Your ref: SSD-67588459
Our ref: DOC24/348280

**Subject: BCS response on Environmental Impact Statement for Powerhouse Ultimo
Revitalisation – 500 Harris Street, Ultimo (SSD-67588459)**

BCS response on Environmental Impact Statement for Powerhouse Ultimo Revitalisation – 500 Harris Street, Ultimo (SSD-67588459)

FFL Flood Level Check Figure 0
**FFL, 1% AEP Flood Level and
PMF Flood Level Sheet
Overview**

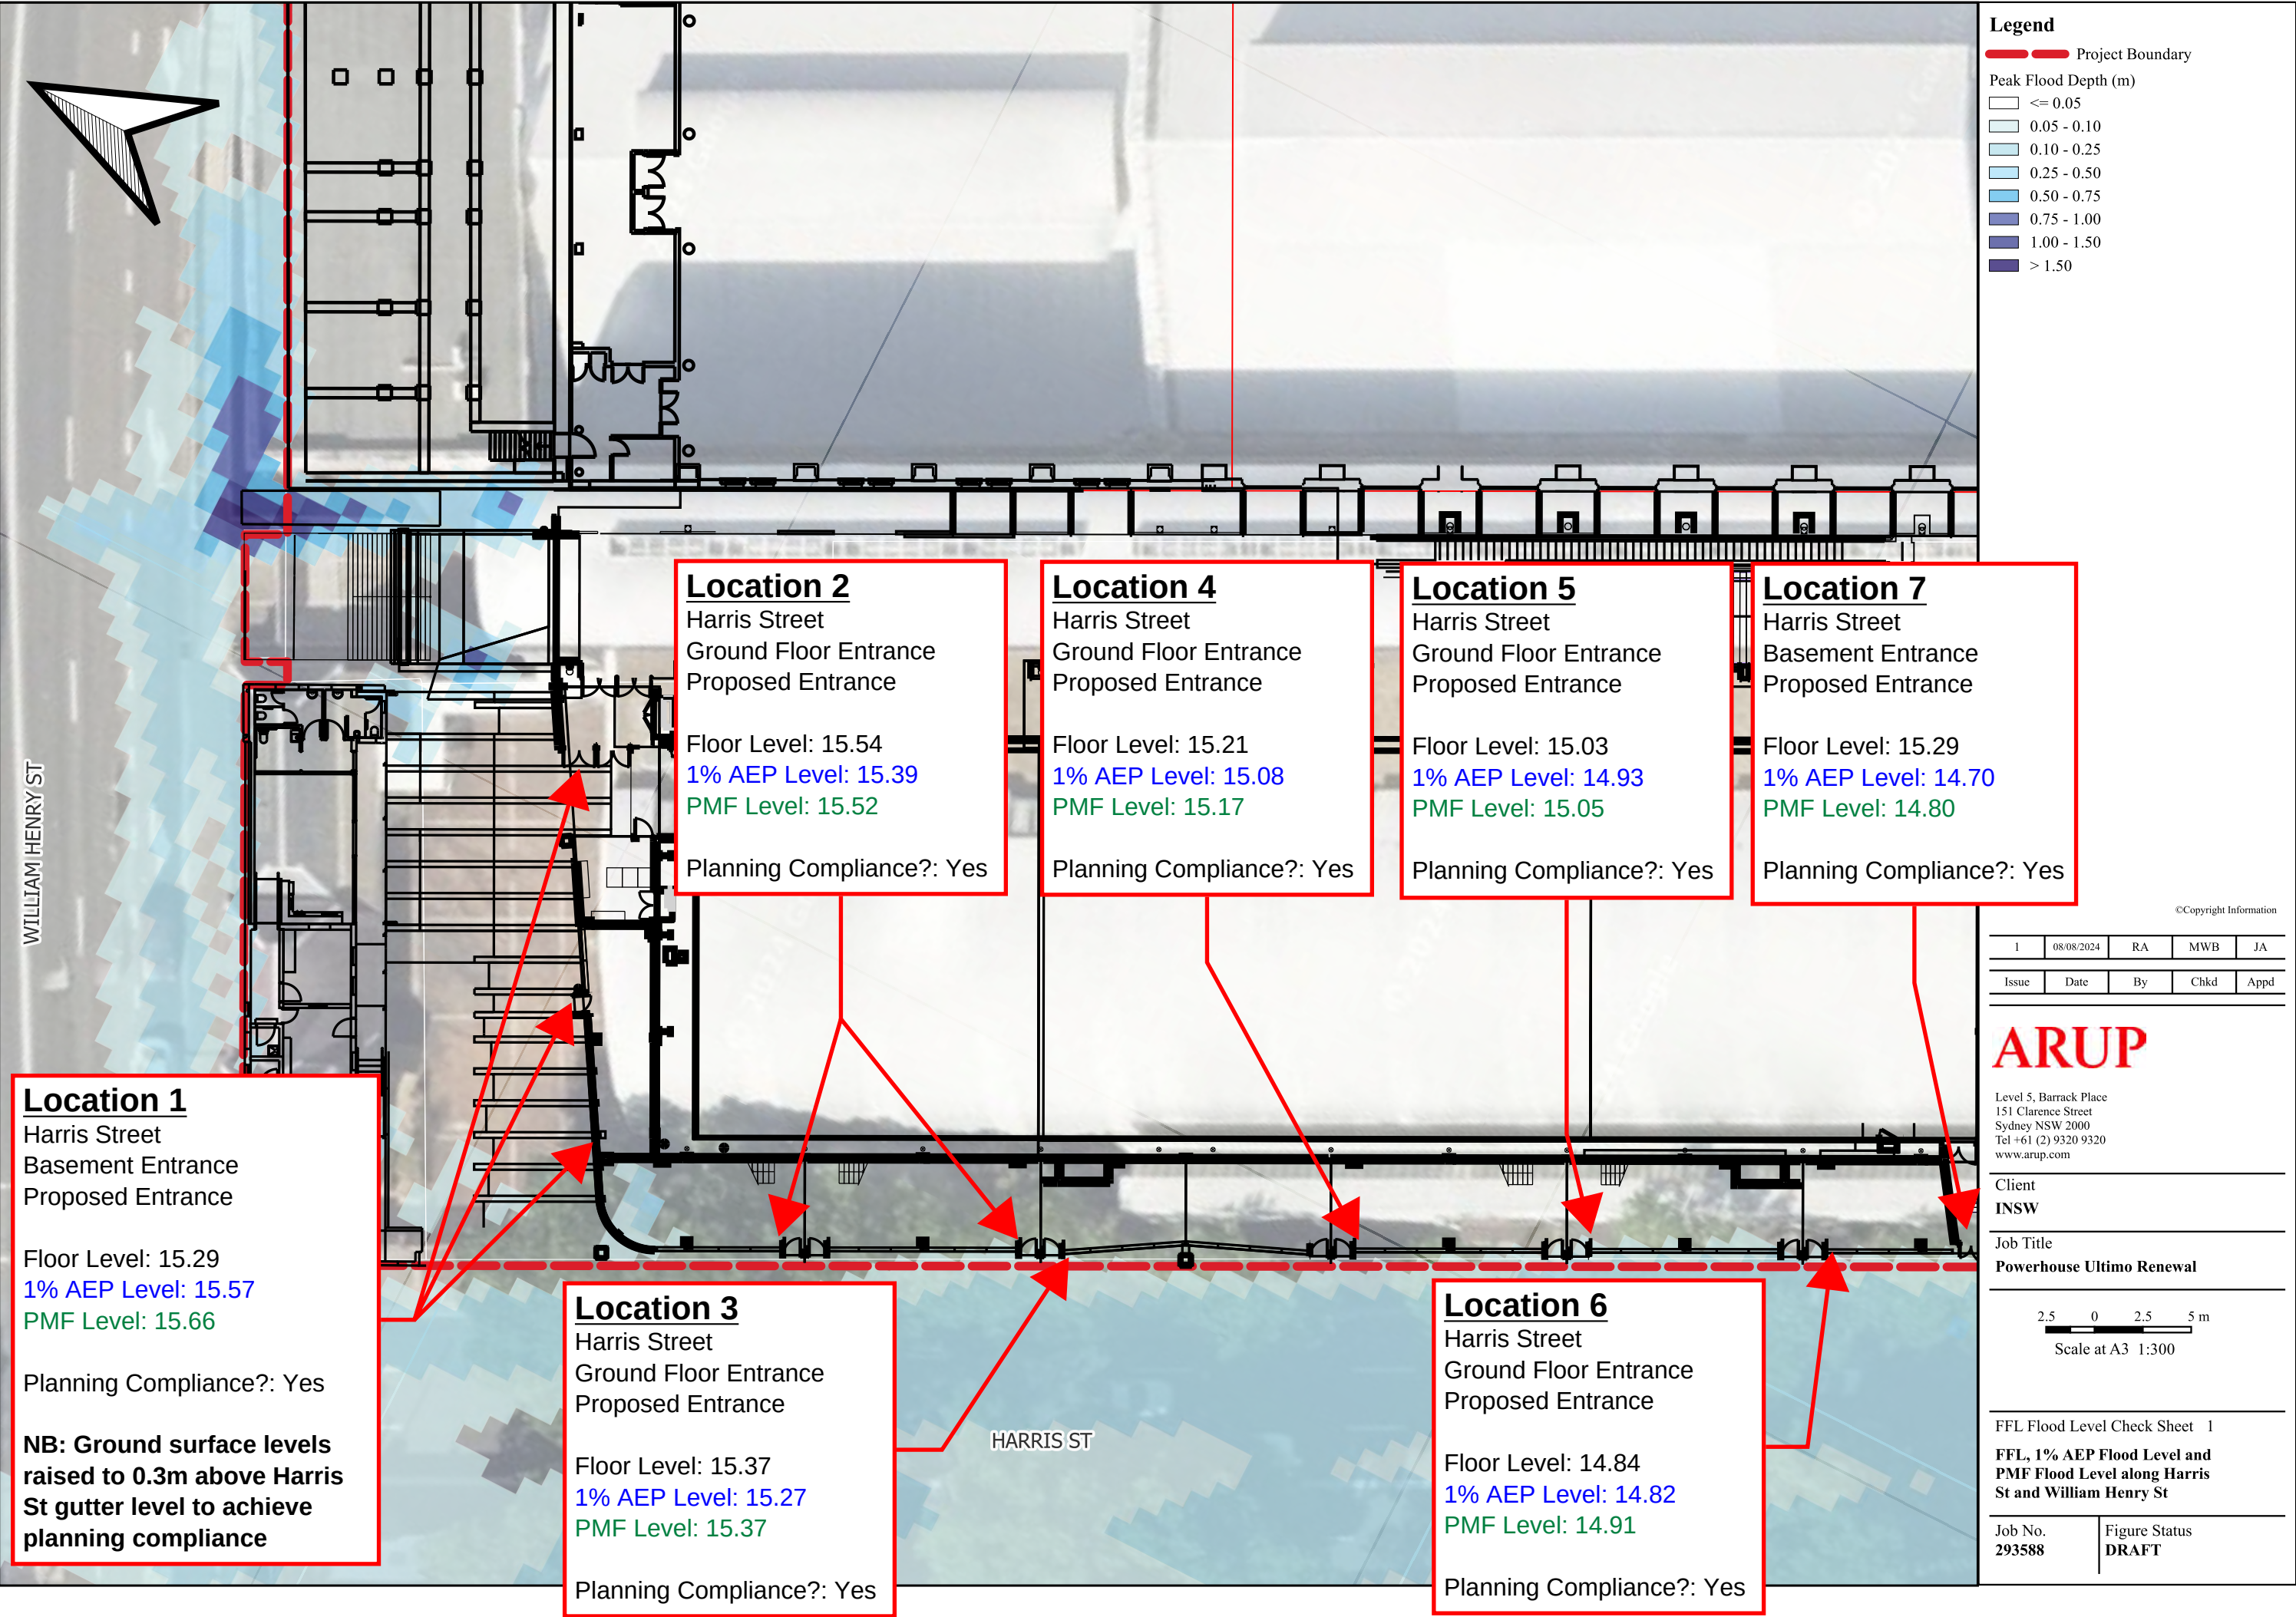
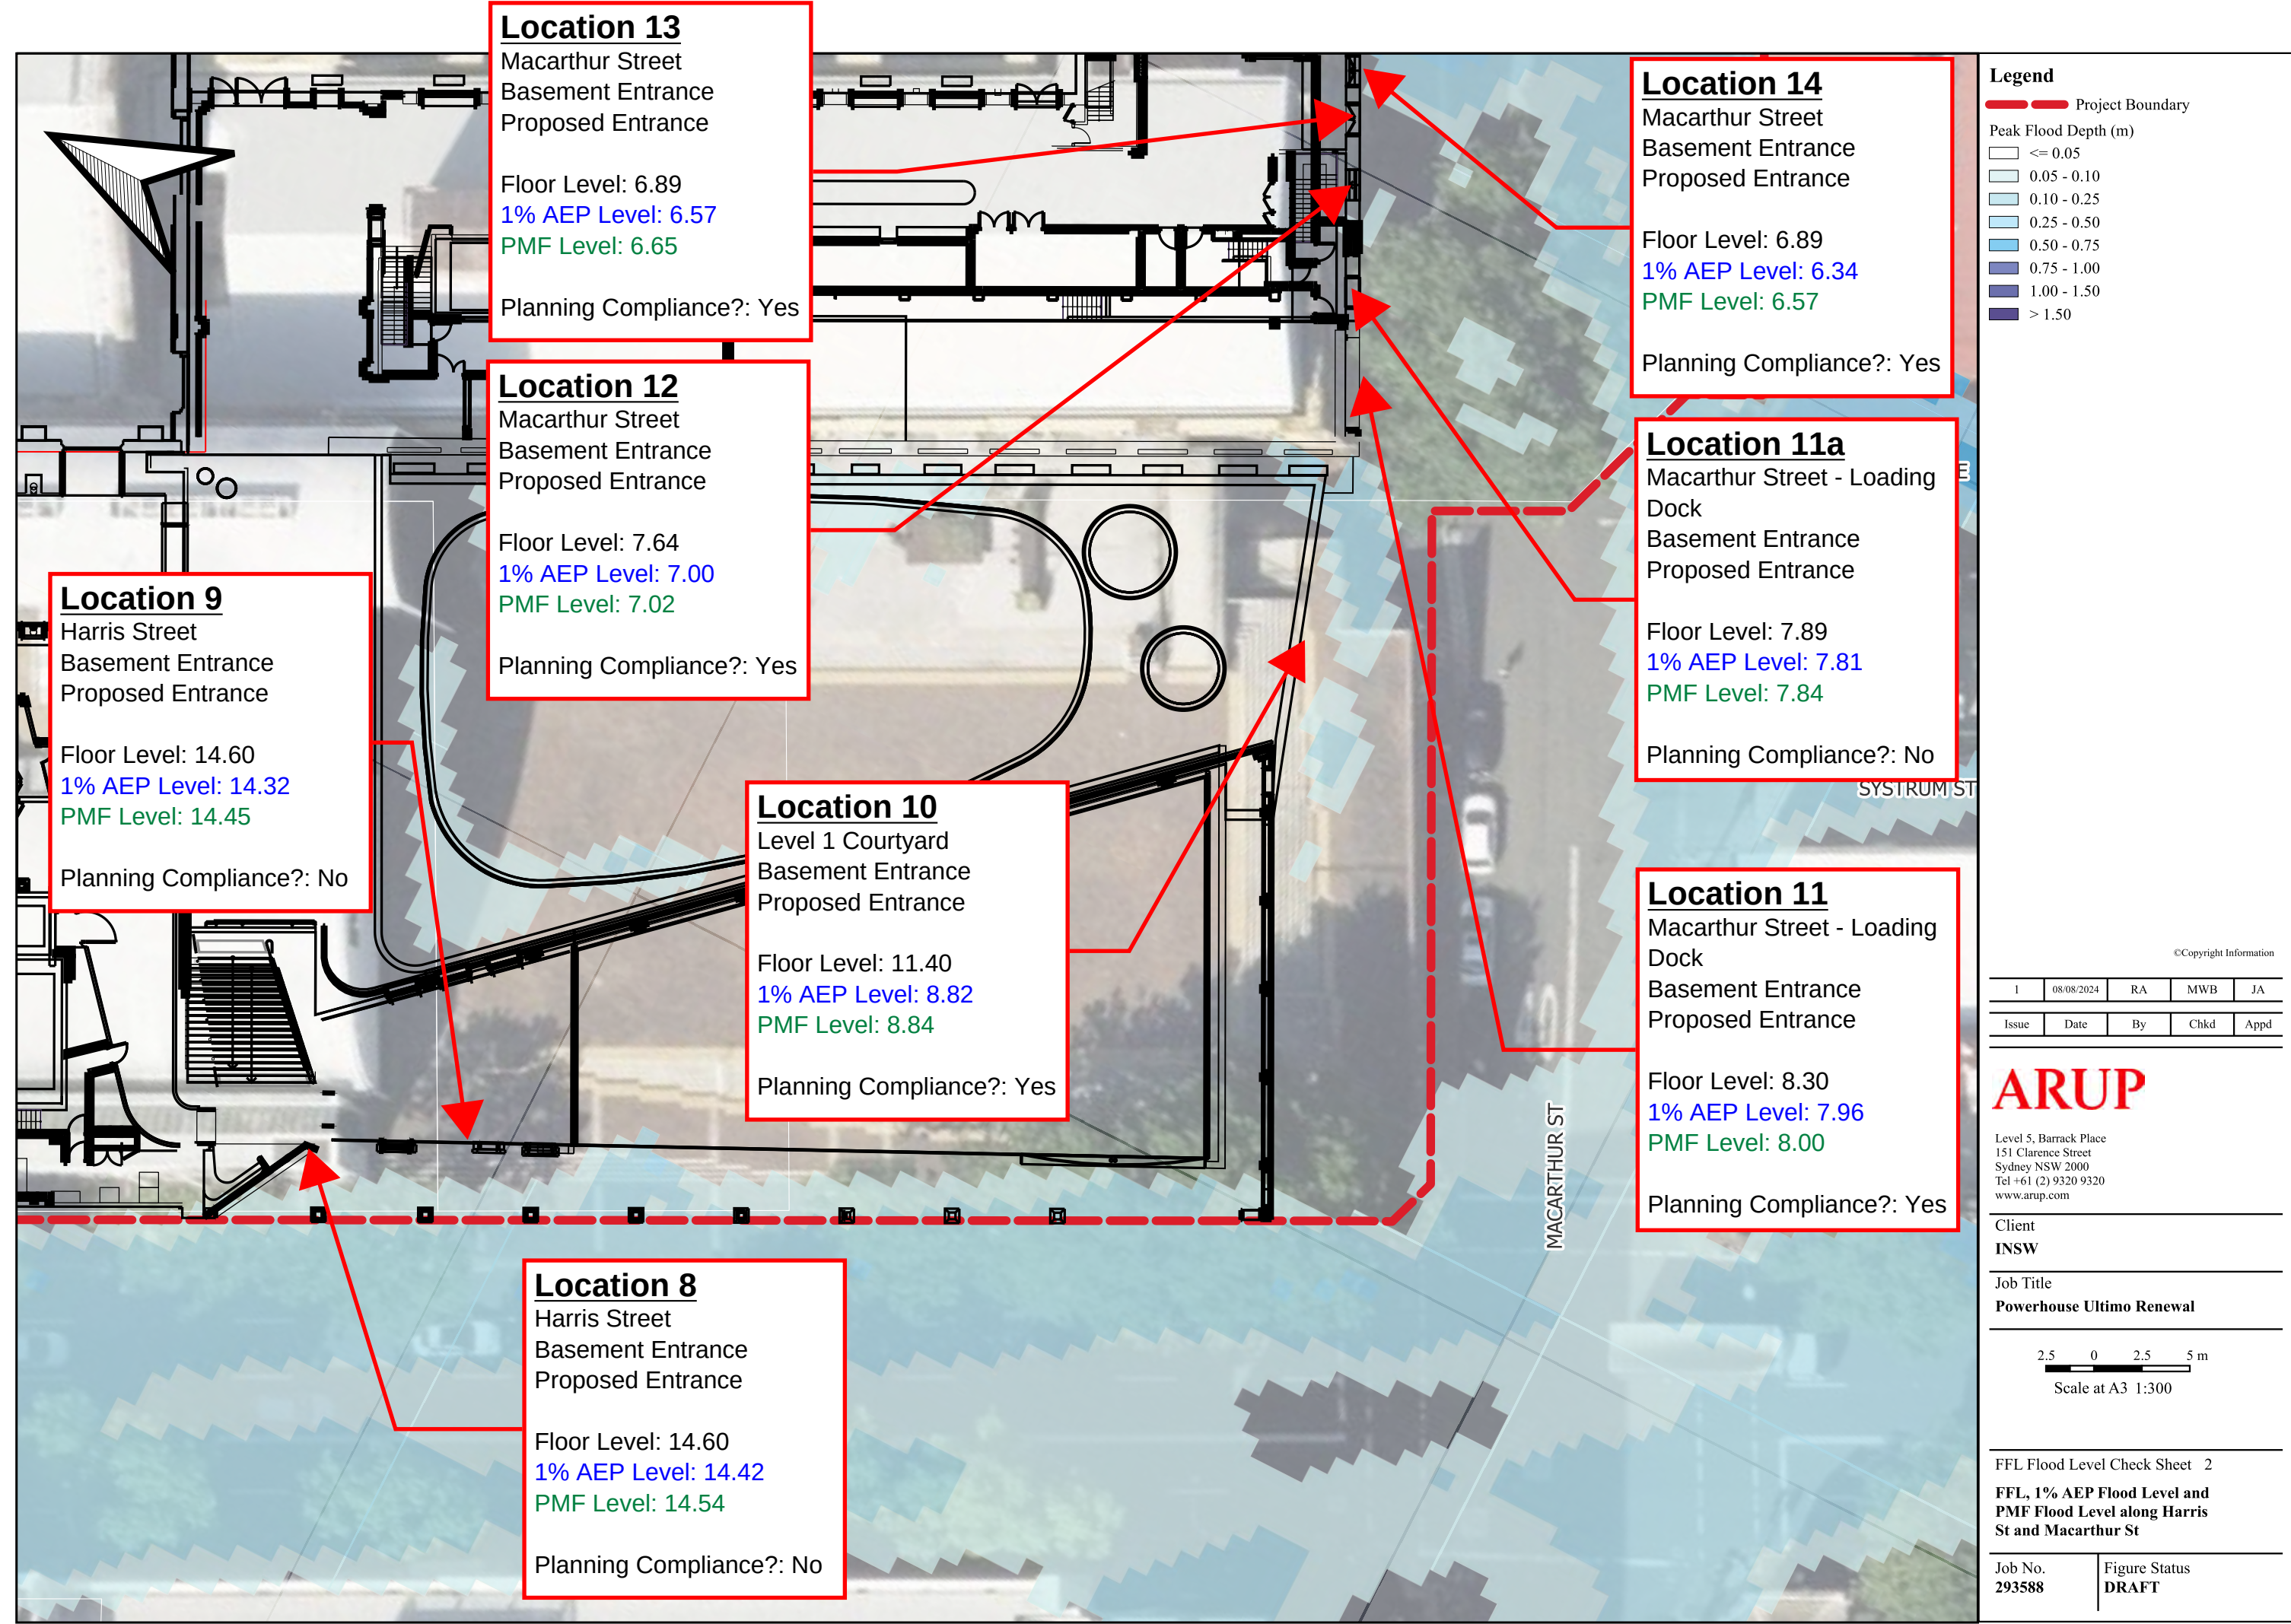
- A plan clearly showing the relevant building entrances together with "flood planning level check locations" shown on Figure 17.
- A description of each location in Tables 15 and 16.
- The water surface levels and depths used to determine flood planning levels should be reviewed against flood depths and levels from a flood model including scrutiny of flood levels adjacent to any new basement entries.

- A plan showing basement entry locations and whether these are existing or proposed.
- Clarification on which basement entries are above the Probable Maximum Flood (PMF) and how much freeboard to the 1% Annual Exceedance Probability (AEP) can be provided where 500mm cannot be reached. Preferably the existing tables would be amended to provide this information.
- Consideration of the flood risk should form part of the justification for a lower level, e.g., depth and duration of flooding. Where protection to the PMF level cannot be reached, calculations can be made to estimate the maximum volume of water likely to enter the basement. The resultant maximum depth can inform a risk assessment.
